KITTITAS COUNTY COMMUNITY DEVELOPMENT SERVICES

August 14, 2014

Subject: Leensvart Boundary Line Adjustment (BL-14-00015)

LOT LINE ADJUSTMENT

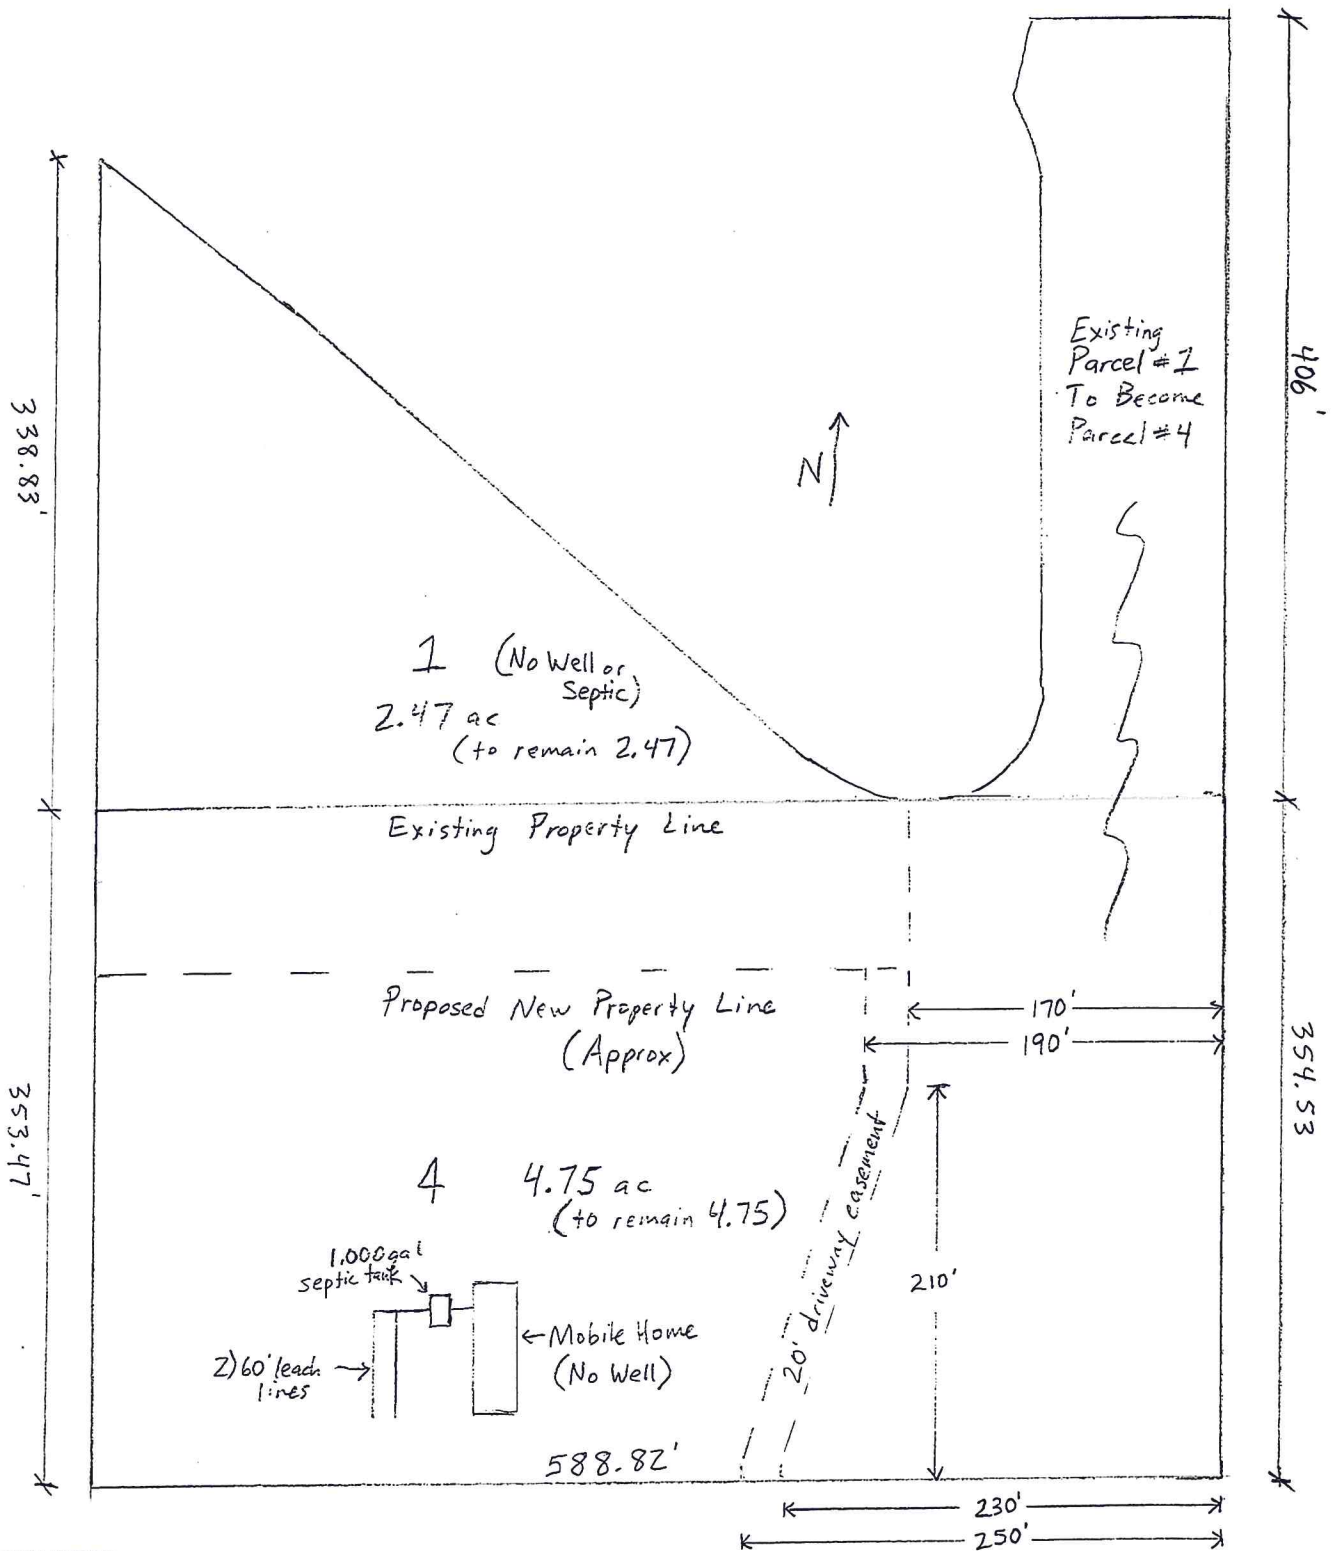
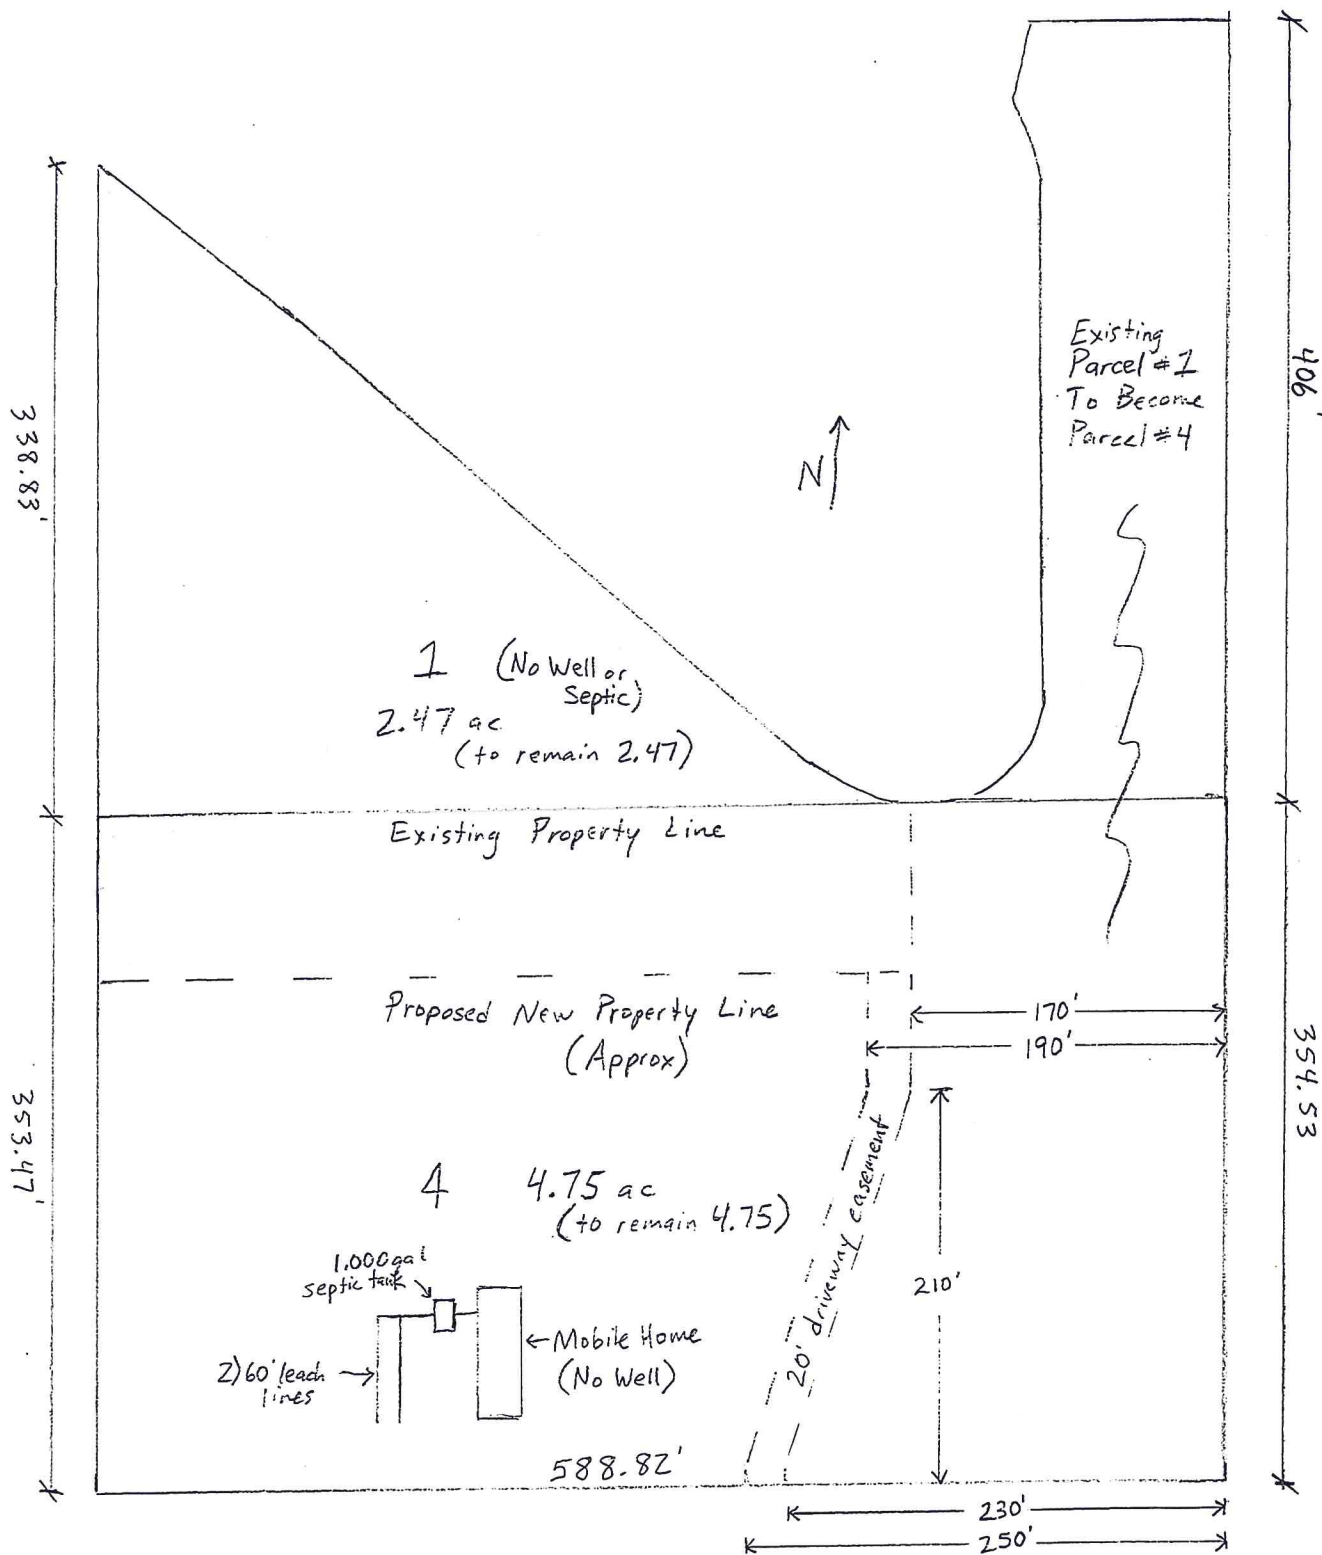
- ***Location of Septic and Wells on all parcels associated with Boundary Line Adjustment on a proposed and existing site plan.***
